**RE: Luther Burbank Waterfront Improvements Project
(SHL22-023, SHL22-024, SHL22-025, CAO22-018, SEP22-019)
Request for Information 1; 2048 84th Ave SE, Mercer Island, WA 98040**

SUMMARIZED CITY PERMIT REVIEW COMMENTS - LUTHER BURBANK WATERFRONT IMPROVEMENTS

PIER IMPROVEMENT PLAN

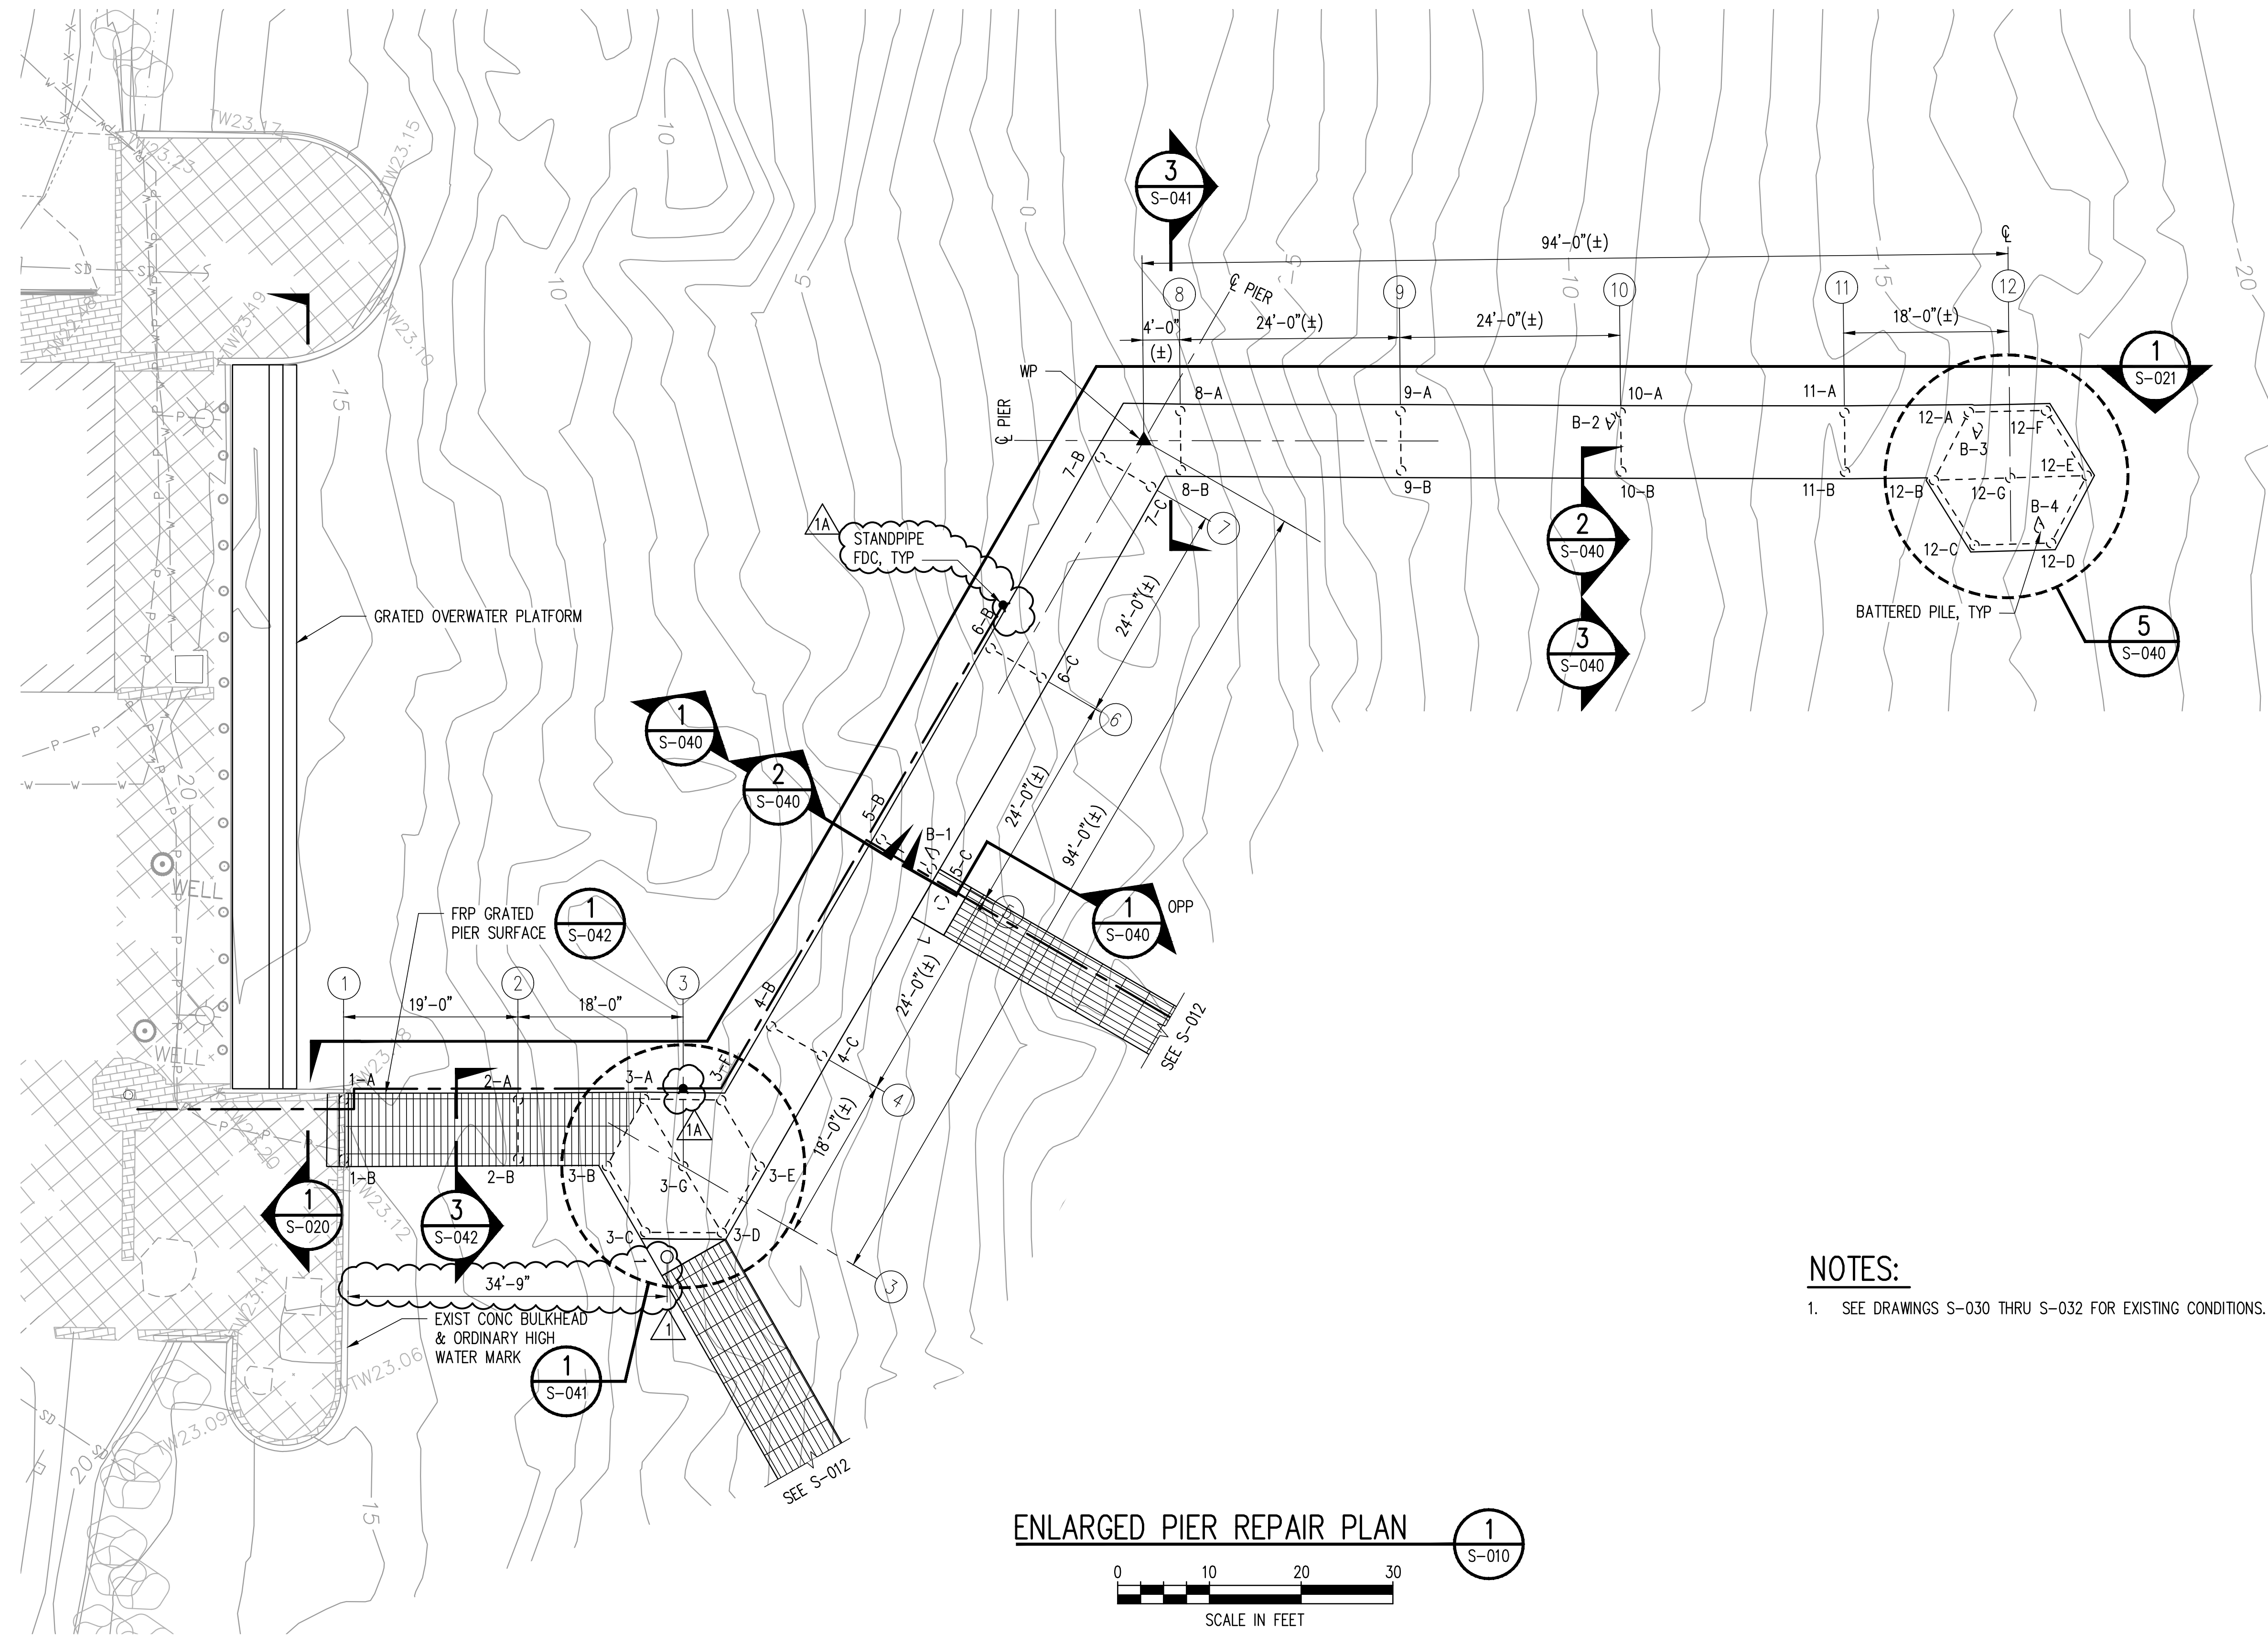
| ITEM NO. | DWG. NO. | Comment | Code | Response | Resolved? |
|----------|----------|--|------|---|-----------|
| 16 | S-010 | Show widths of all docks | A | Widths added for all docks. Please see attached redline to be drafted at 90% | |

PIER AND FLOATS ELEVATION

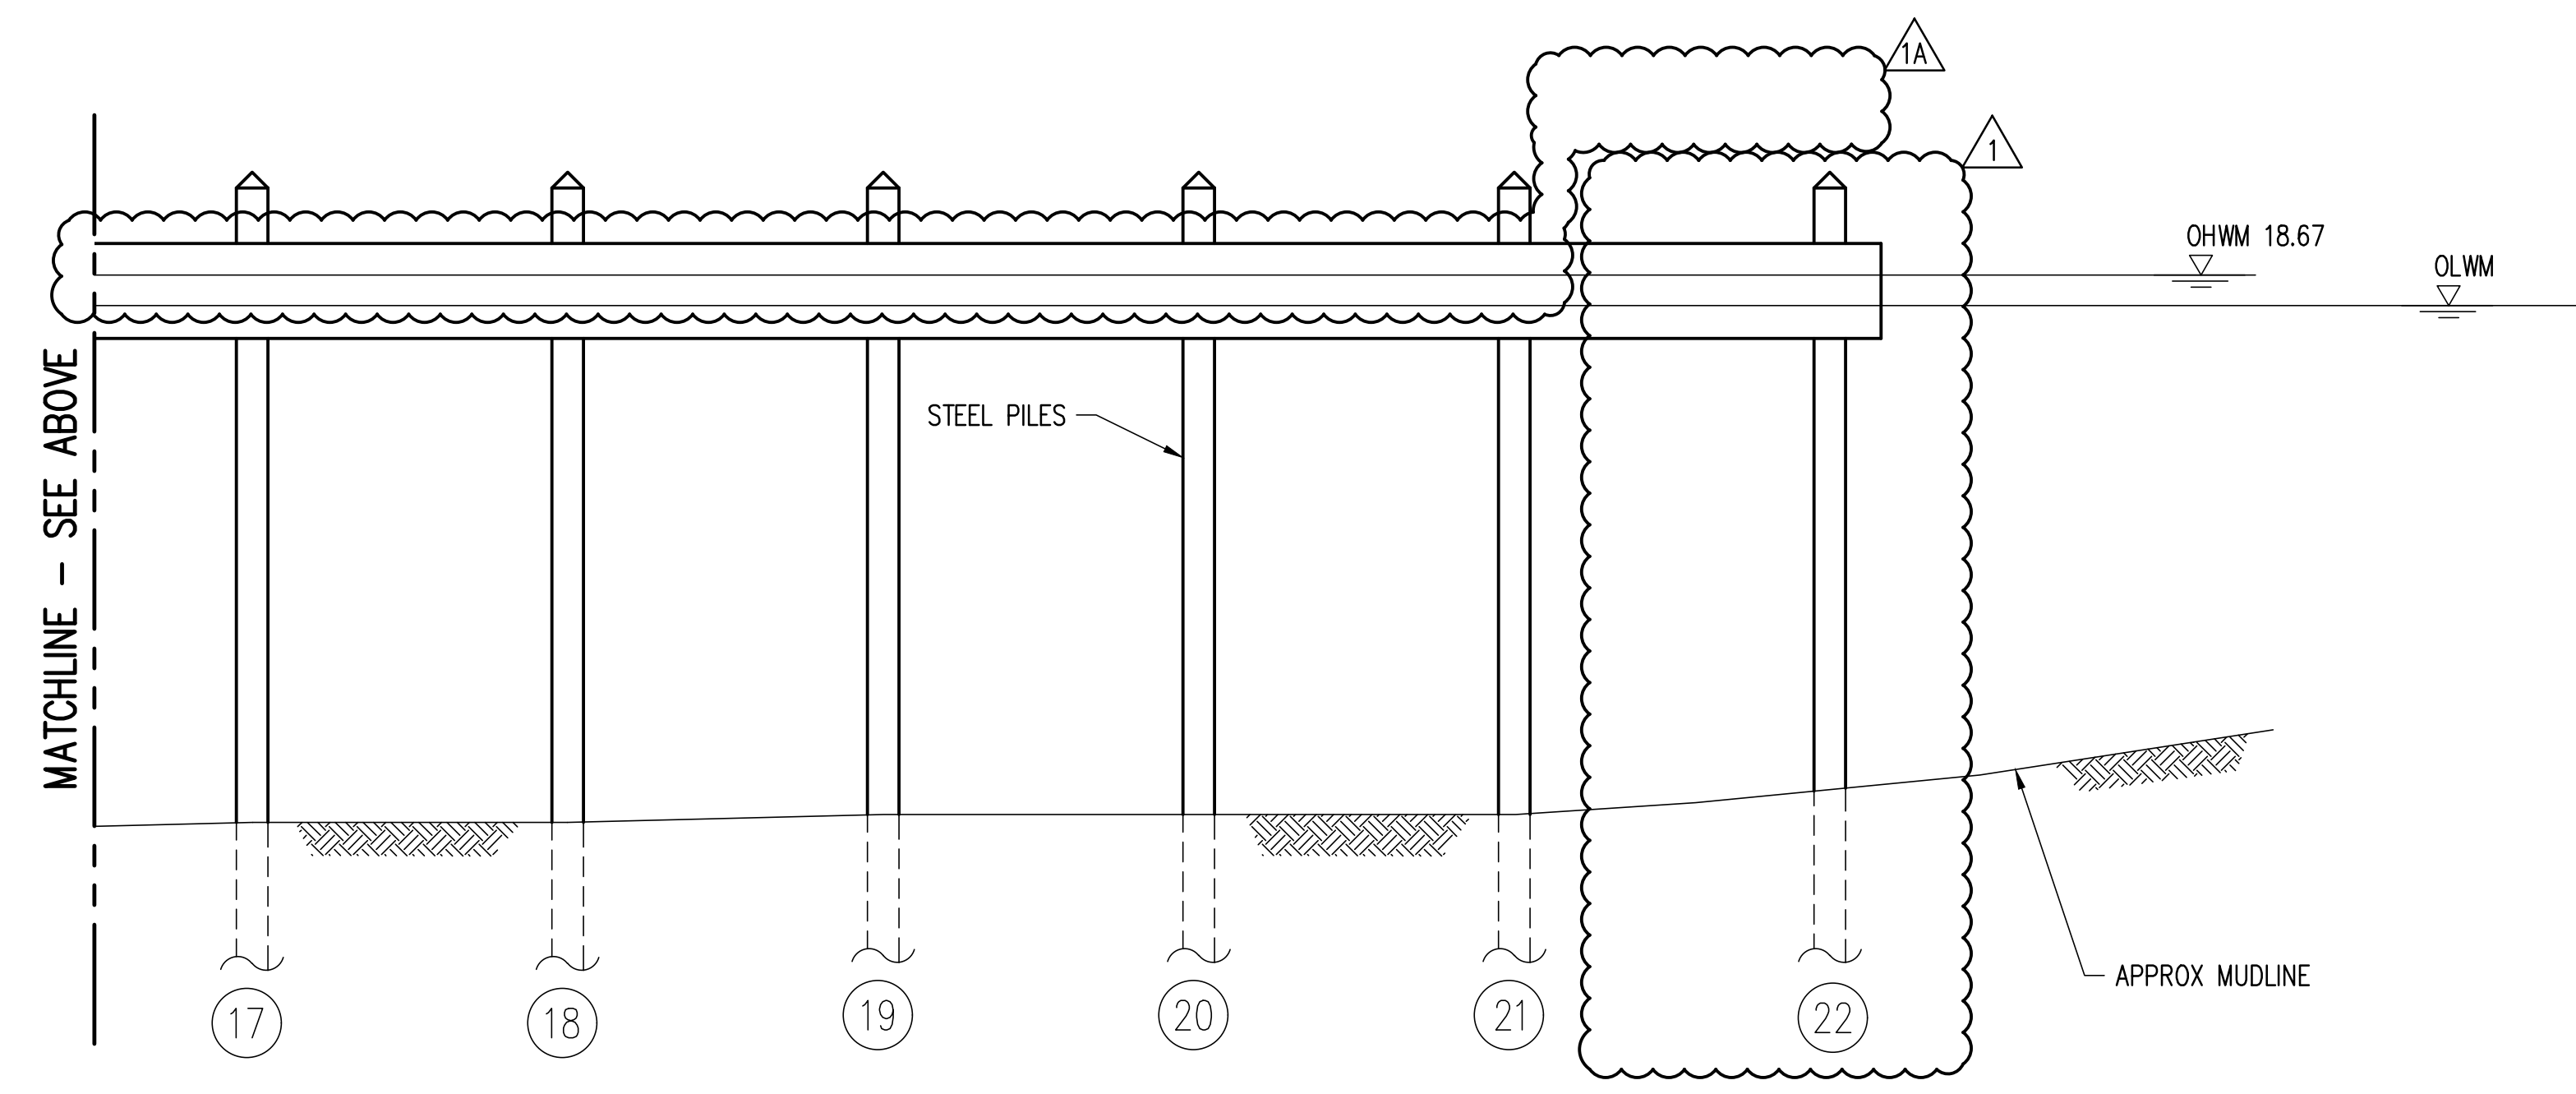
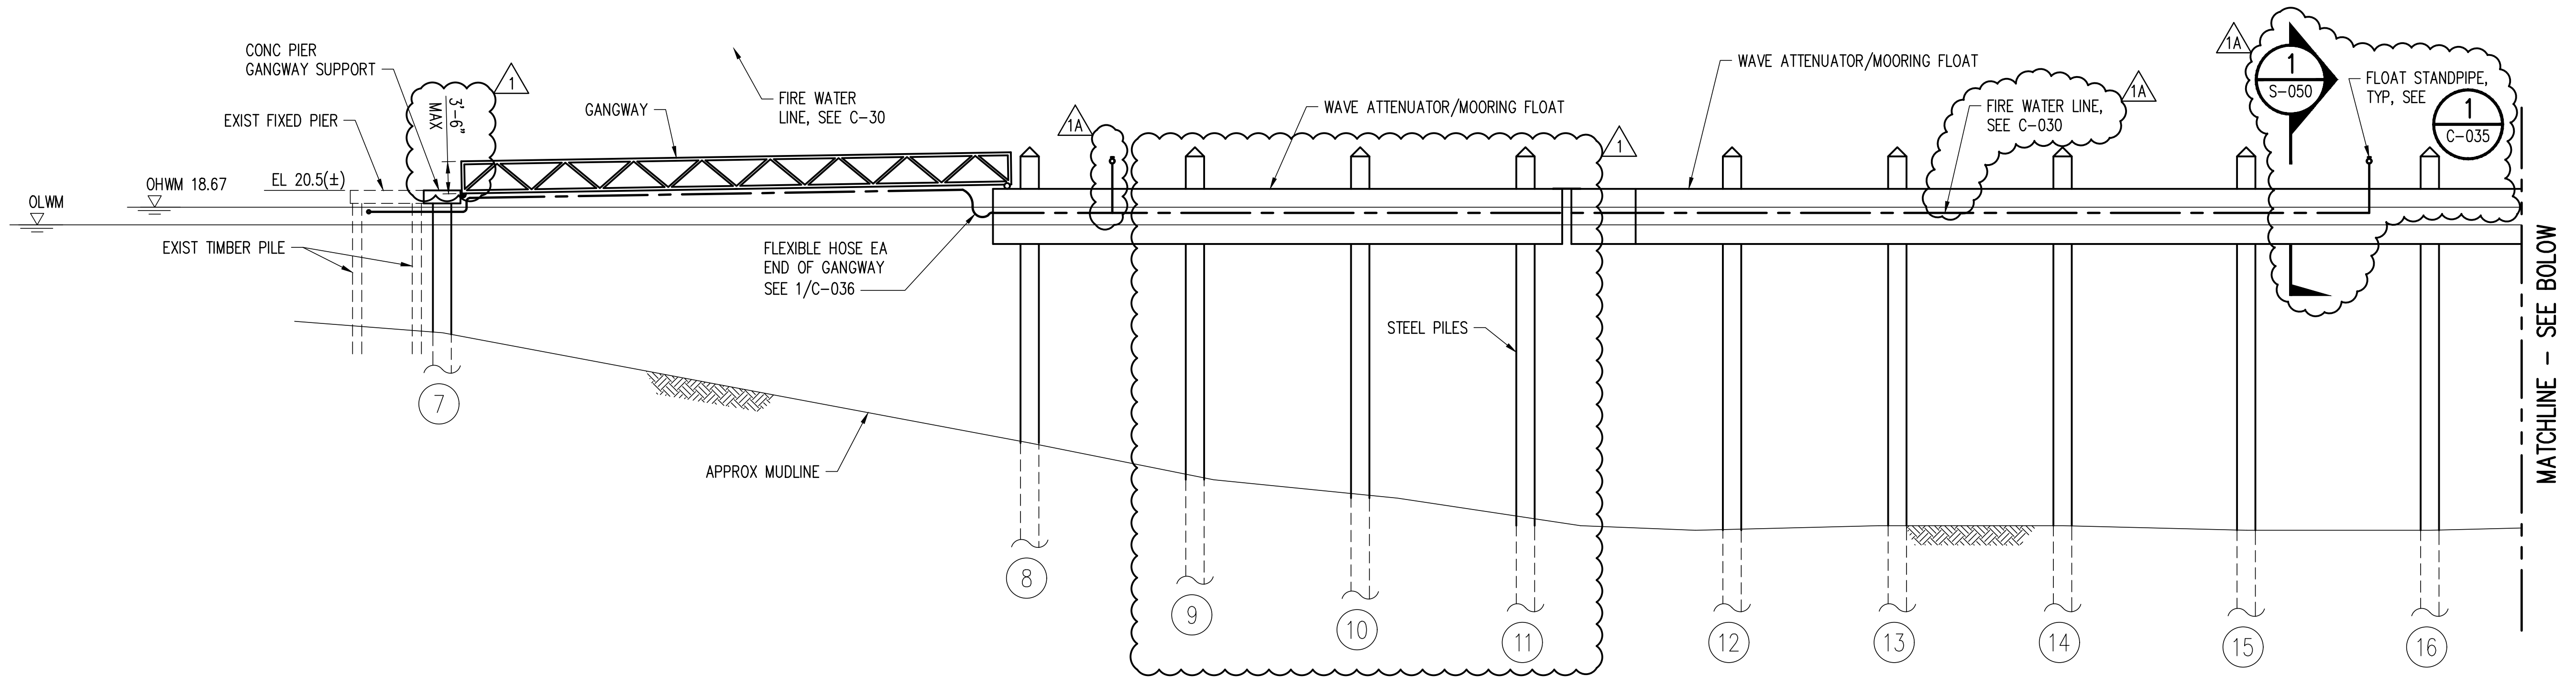
| ITEM NO. | DWG. NO. | Comment | Code | Response | Resolved? |
|----------|----------|--|------|---|-----------|
| 17 | S-021 | Show distance between piles and distance of first set from OHWM for compliance with MICC 19.13.050(H)(7) | A | Distance between piles shown on S-012. Distance between first pile and OHWM added to S-10, S-11, and S-12. Please see attached redlines to be drafted at 90%. | |

| ITEM NO. | DWG. NO. | Comment | Code | Response | Resolved? |
|----------|----------|---|------|---|-----------|
| 18 | S-021 | Show height of gangway for compliance with MICC 19.13.050(D) maximum height limits | A | Maximum height limit added. | |
| 20 | S-022 | Show distance between piles and distance of first set from OHWM for compliance with MICC 19.13.050(H)(7) | A | Distance between piles shown on S-012. Distance between first pile and OHWM added to S-10, S-11, and S-12. Please see attached redlines to be drafted at 90%. | |
